3/17/26

I-5719B_U5800_Submittal S-008-4B Plans
MI-Engineering- Hydraulics Review

PROJECT REFERENCE NO. L-5719B / U-5800	SHEET NO. 11
RW SHEET NO.	HYDRAULICS ENGINEER
ROADWAY DESIGN ENGINEER	
DOCUMENT NOT CONSIDERED FINAL UNLESS ALL SIGNATURES COMPLETED	
HDR Engineering, Inc. of the Carolinas 555 Fayetteville St., Suite 900 Raleigh, N.C. 27601 N.C.B.E.L.S. License Number: F-0116

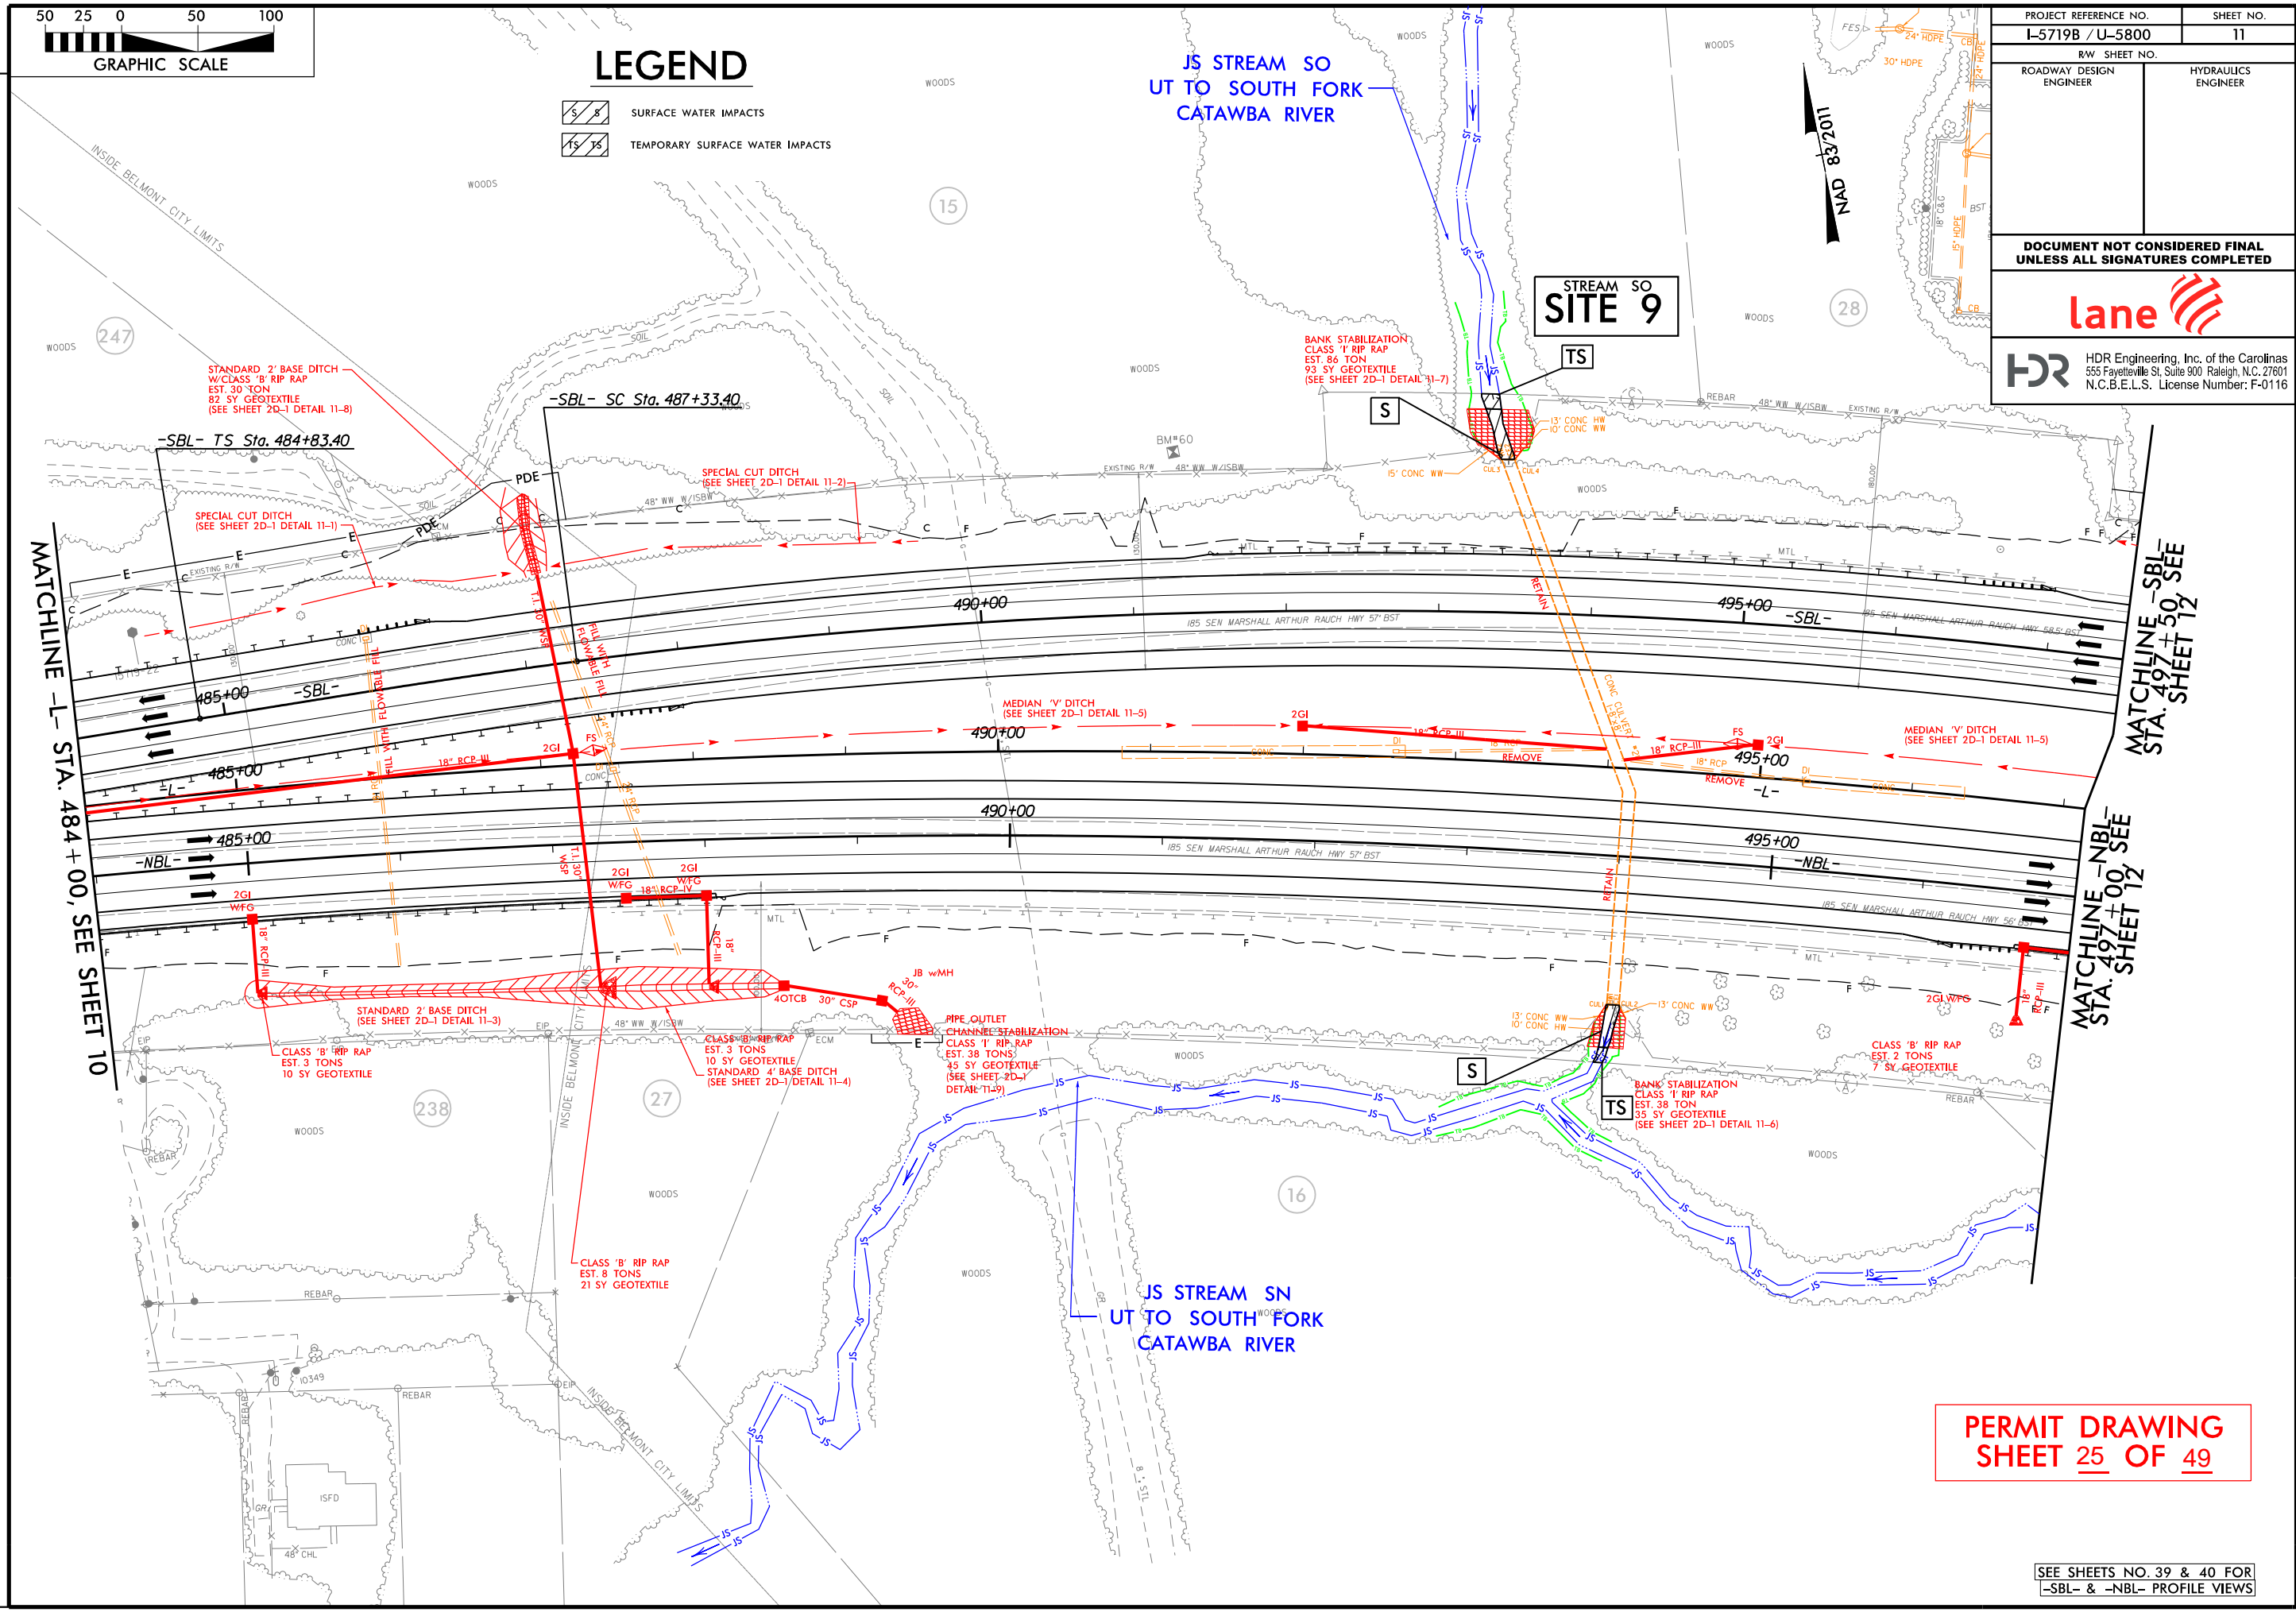
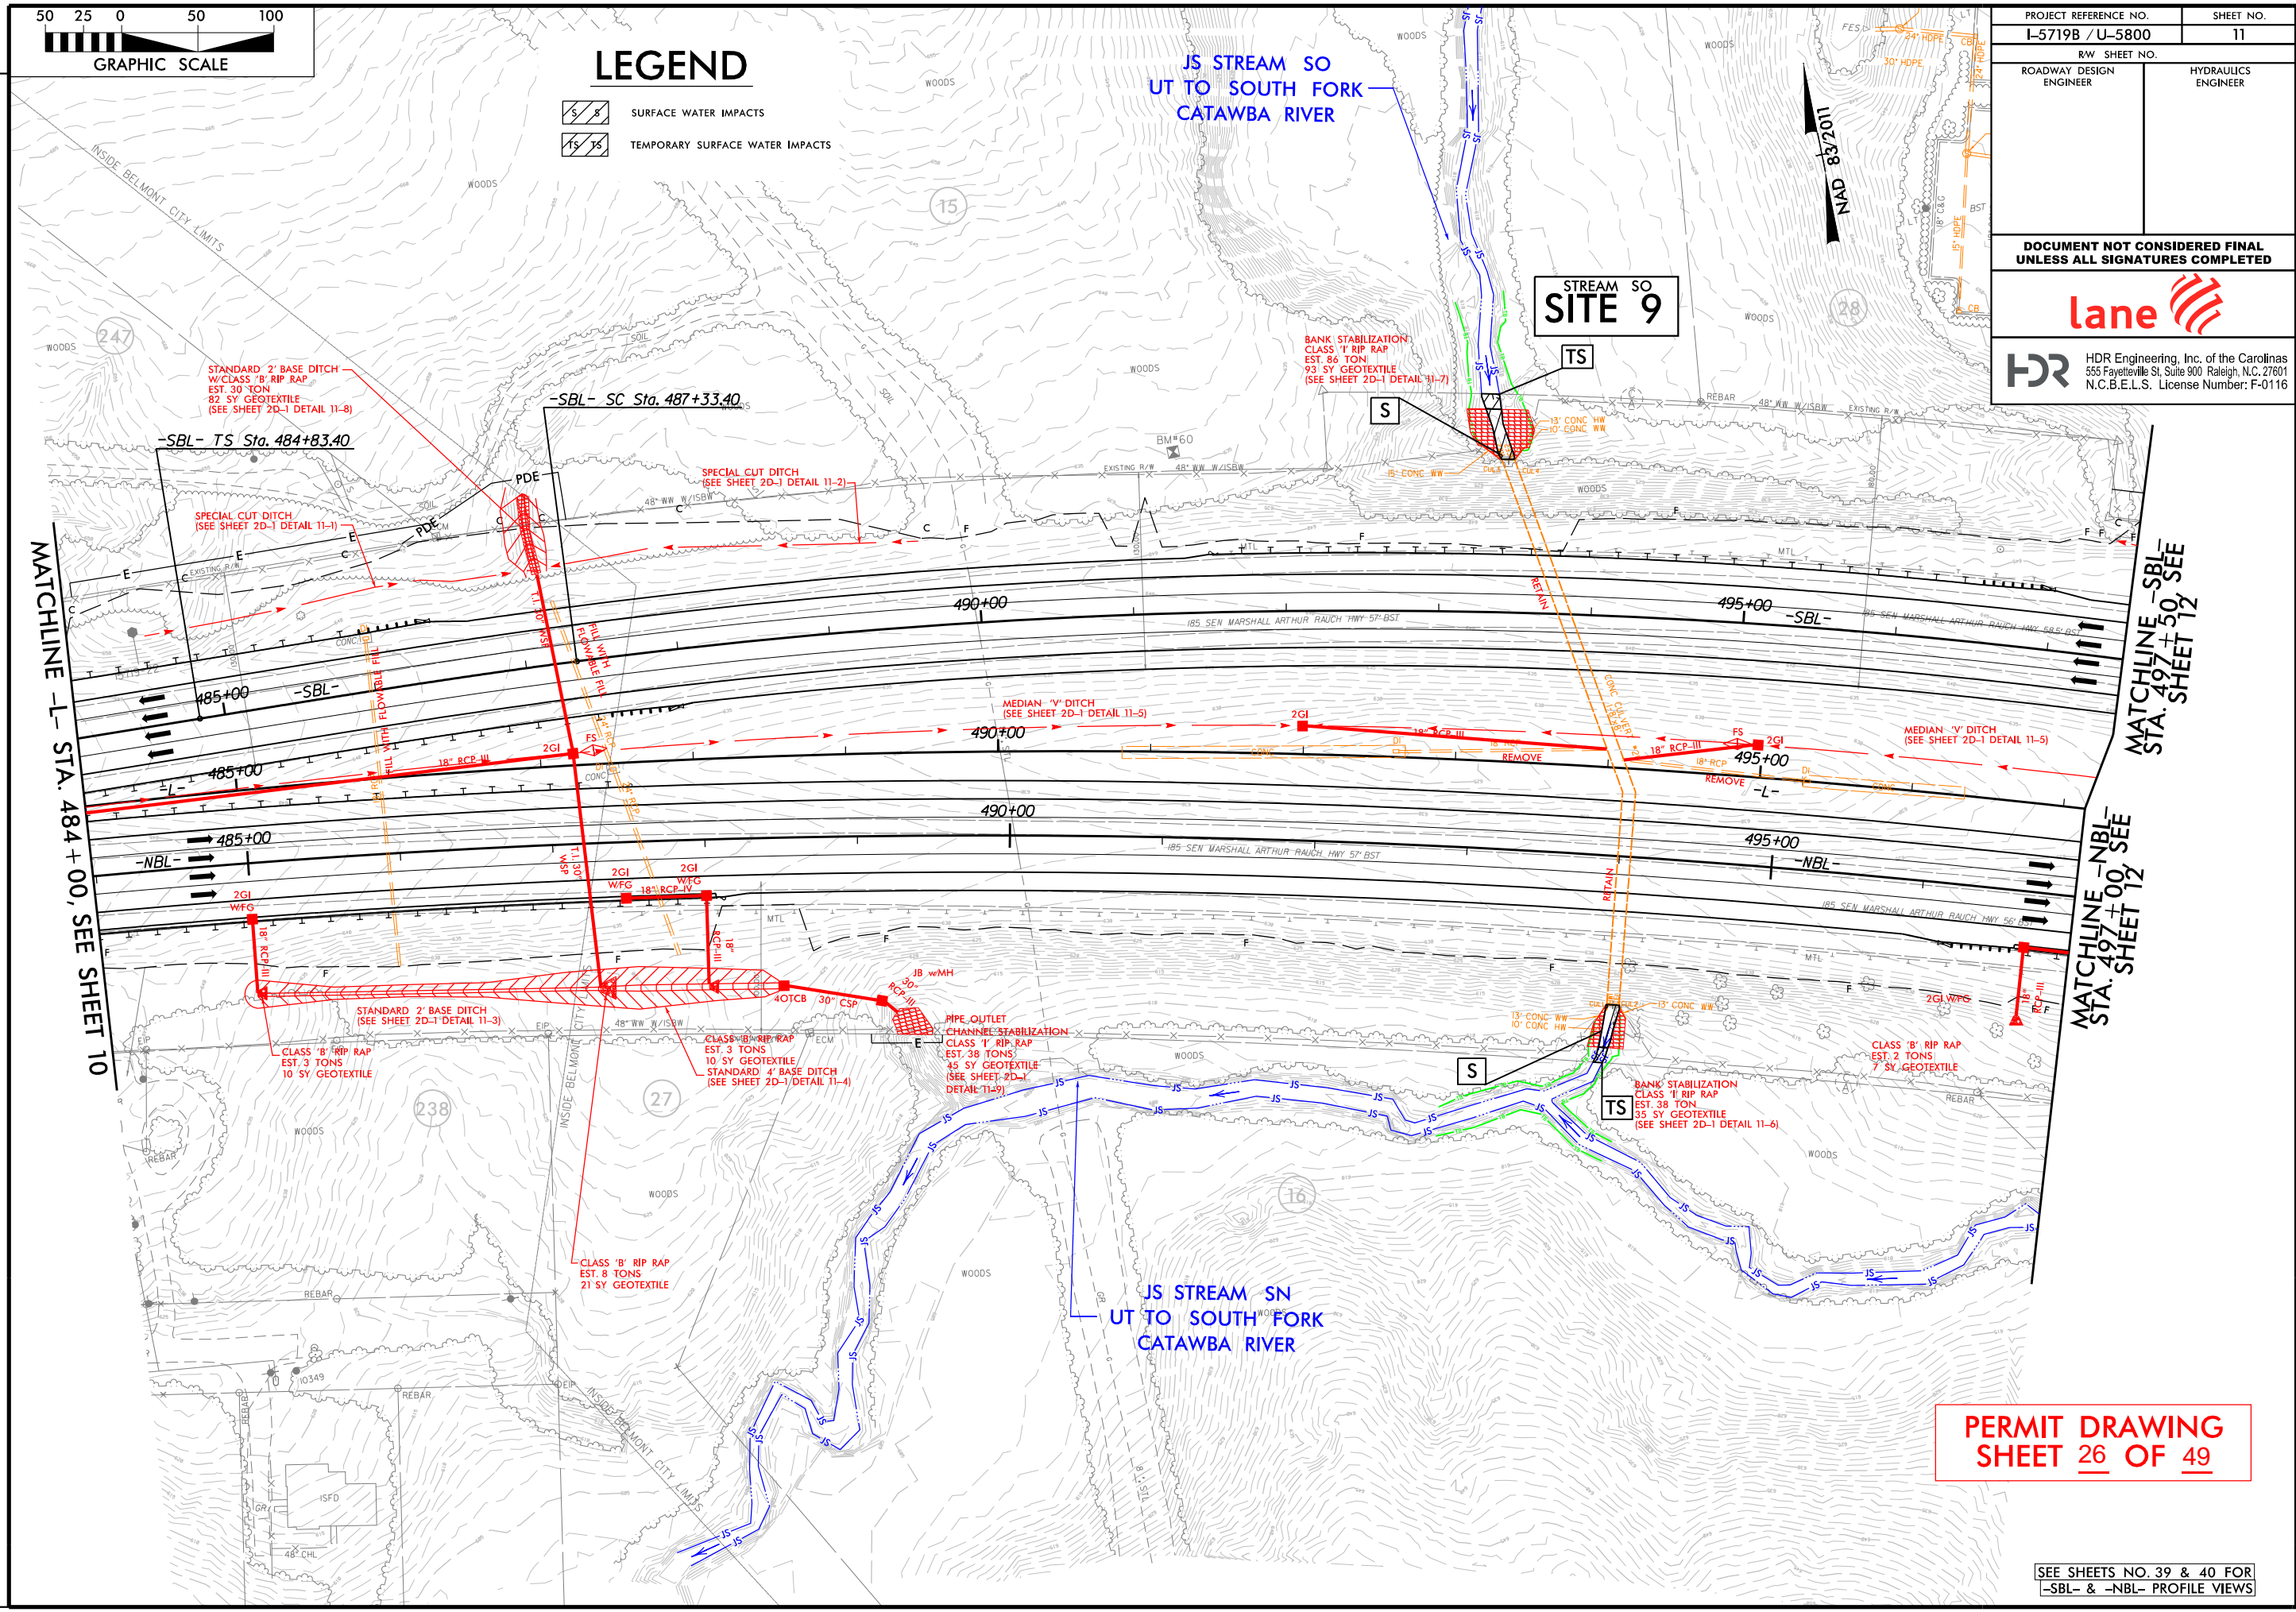
- Should outfall right of station 489+50 be lined with rip rap all the way to the confluence of creek? See markup.
 - The design includes the use of a drop box and flat pipe to reduce velocities as well as channel protection up to the ROW line. No other work is proposed on the adjacent property and would require additional ROW.
- 8'x8' RCBC station 494+08. Have culvert slope and channel dimensions available and ready for discussion on sills. –
 - Discussion for meeting.

PROJECT REFERENCE NO. L-5719B / U-5800	SHEET NO. 13
RW SHEET NO.	
ROADWAY DESIGN ENGINEER	HYDRAULICS ENGINEER
DOCUMENT NOT CONSIDERED FINAL UNLESS ALL SIGNATURES COMPLETED	
HDR Engineering, Inc. of the Carolinas 555 Fayetteville St., Suite 900 Raleigh, N.C. 27601 N.C.B.E.L.S. License Number: F-0116

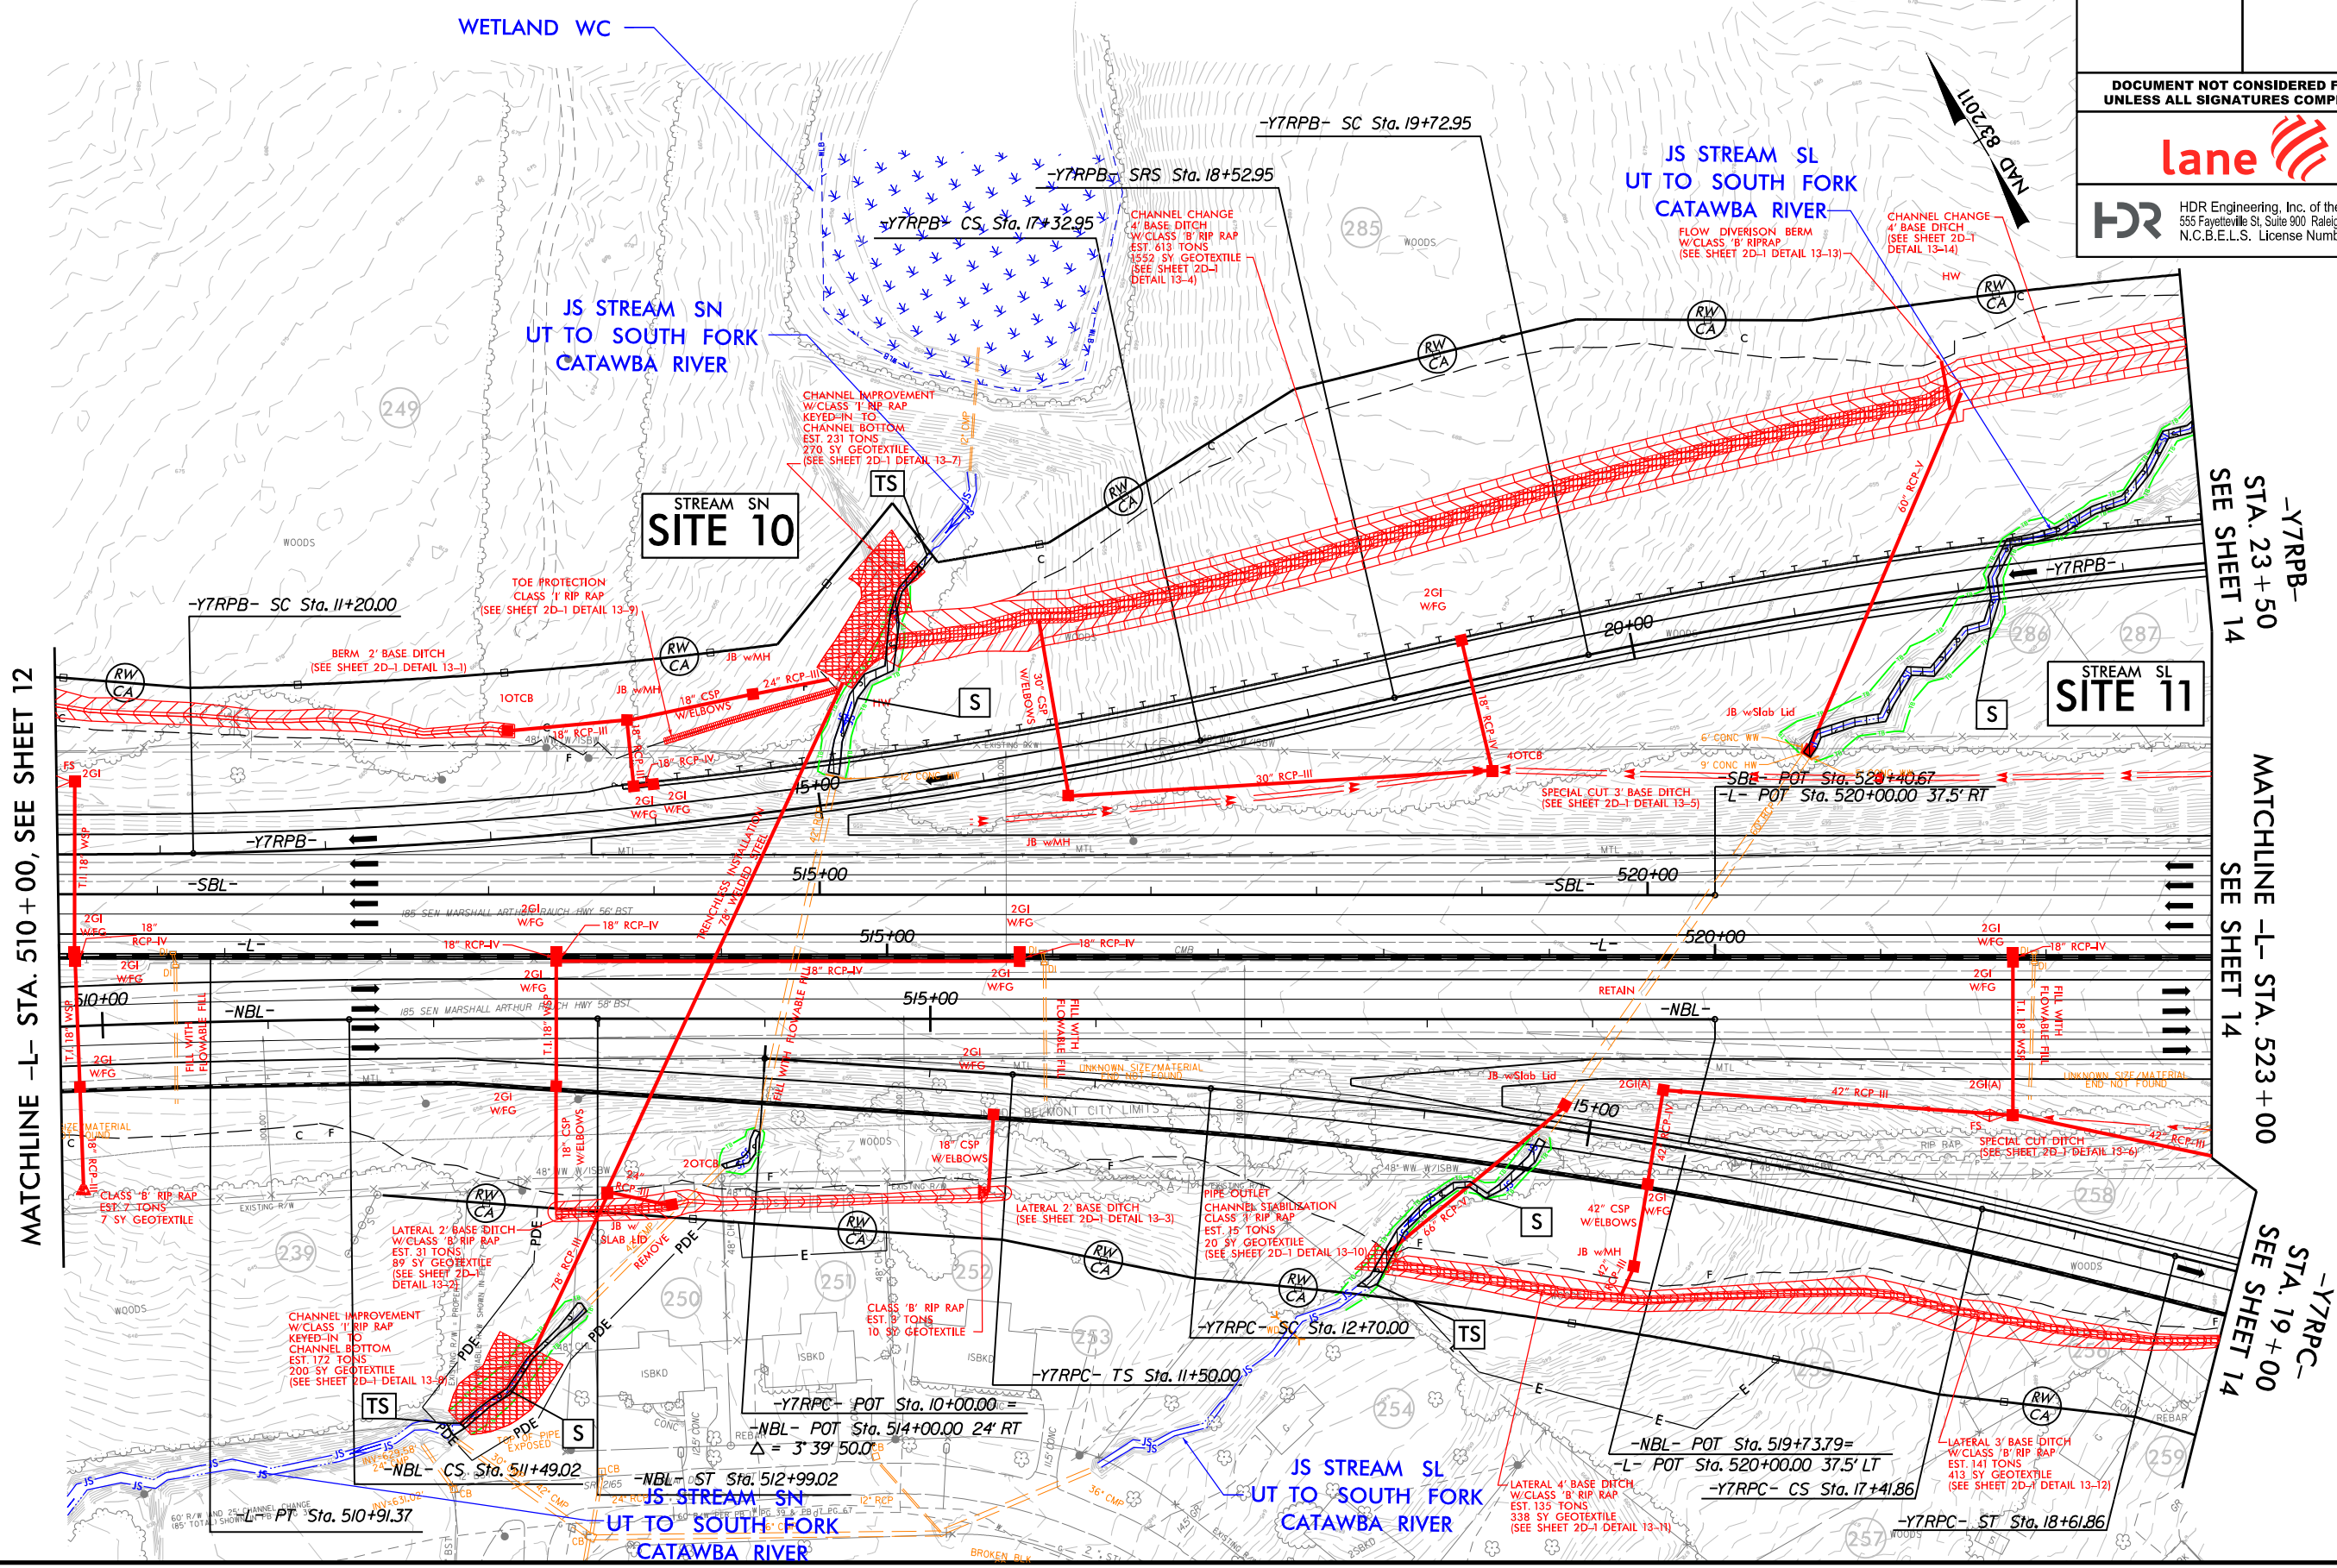
- 84" pipe at station 513+96. Are sills proposed for this pipe?
 - Discussion for meeting.
- There is an area labeled wetland in the survey file right of station 512+50 that may need clarification. It is not shown in the NRTR. –
 - Wetland label removed.
- 60" pipe at station 519+70. Recommend keying rip rap into stream bed at outlet since upstream channel is fully lined with rip rap.
 - Riprap was revised to show key-in to channel bottom.
- Is the intent to rip rap the entire channel and 5' berms on either side of the channel for details 13-4 and 13-13? The details only show lining banks to a depth of 1'.
 - The details have been revised to show the full lining. However, this area is still under investigation and riprap may be reduced from what is currently shown.
